26 August 2021

Ref No: F2021/01408

RE: KAMAY FERRY WHARF PROJECT SSI-10049

Figure 10-9: Construction impacts at La Perouse

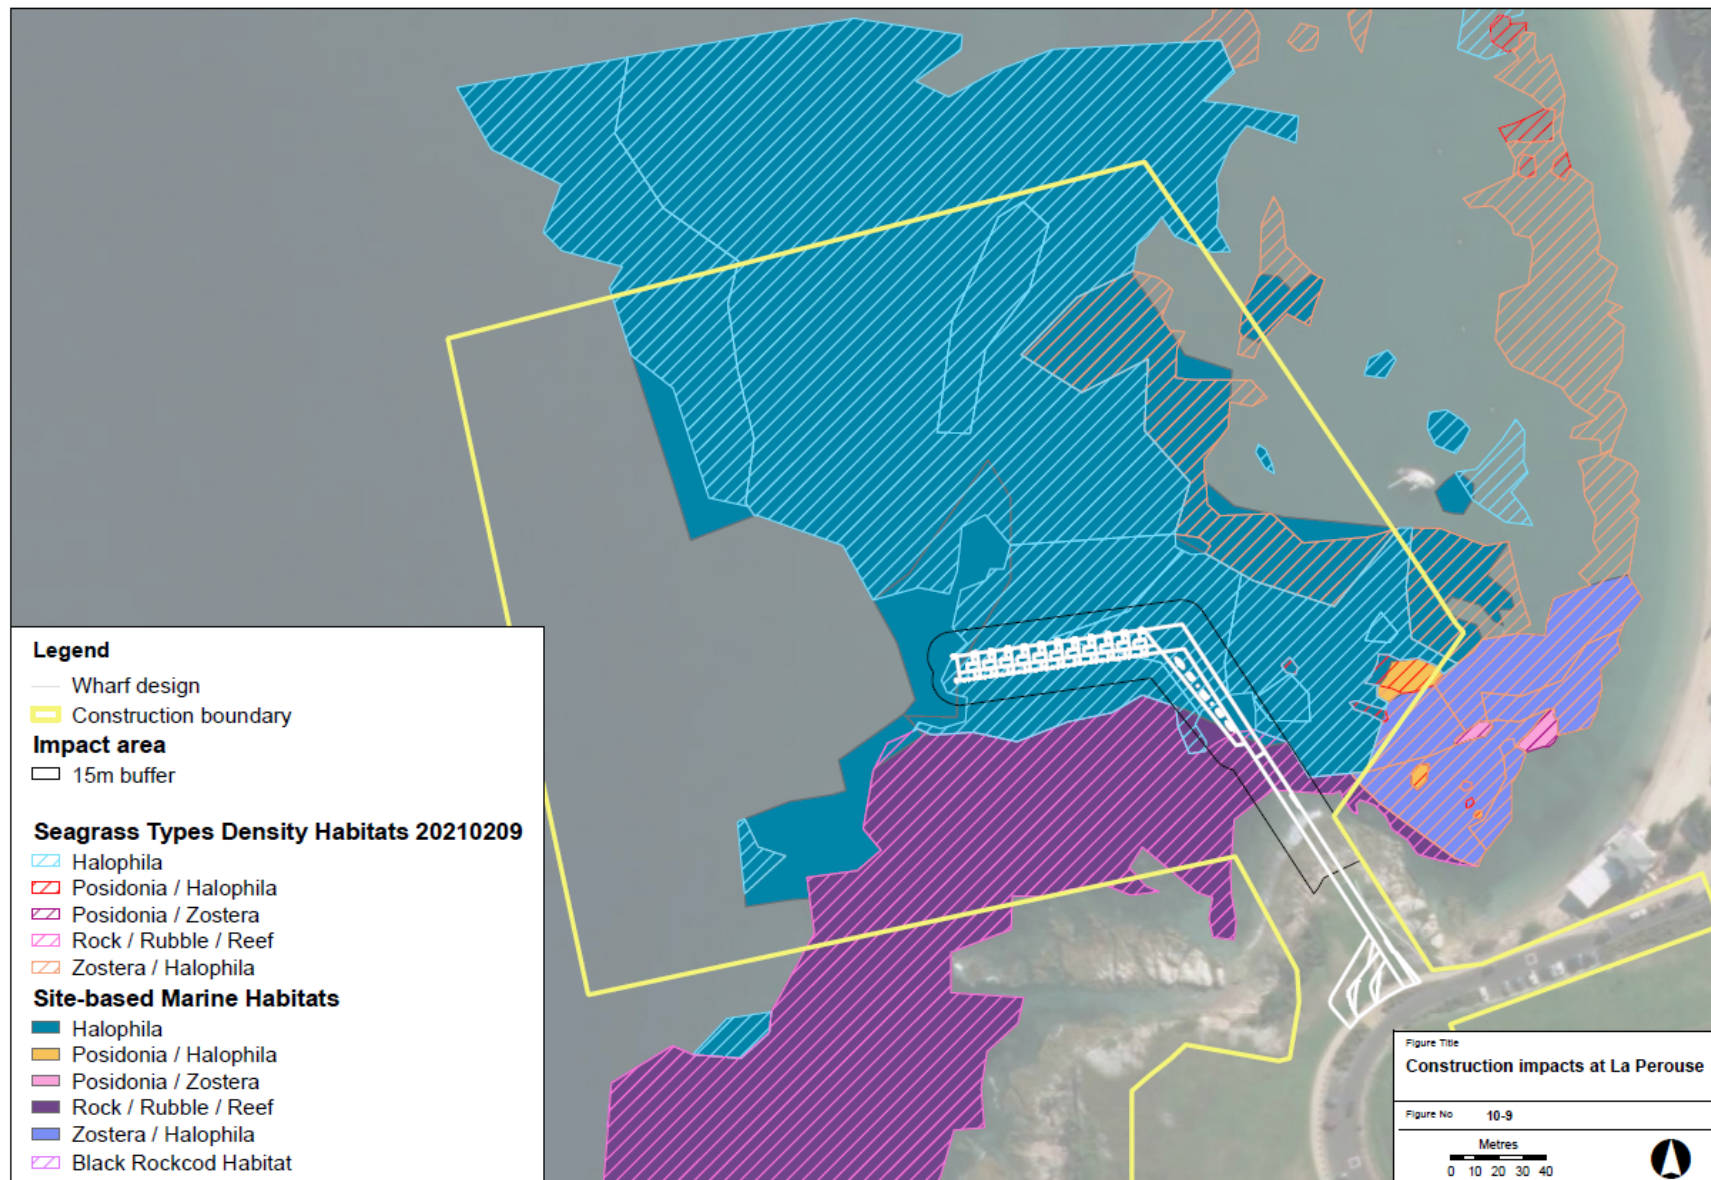
Council is concerned about potential impacts of sediment dispersal during construction activities such as piling and the impacts this may have on the nearby sea grass beds and sensitive marine biodiversity. Council notes that a large number of piles are required at both sites to support the access jetties and that the Cardno memorandum states that this process will displace/disturb the bottom sediments and thereby lead to the production of suspended sediment plumes.

Contrary to the Cardno report, Council suggests that silt curtains be investigated for use throughout piling and sediment disturbing construction activities to minimise impacts to mitigate impacts of sediment dispersal and seagrass smothering. It should be noted that silt curtains were extensively used around construction zones in the Port Botany Expansion project in 2009 to reduce impact on the retained seagrass along Foreshore Beach and are a proven method to minimise sediment dispersal from disturbance activities.
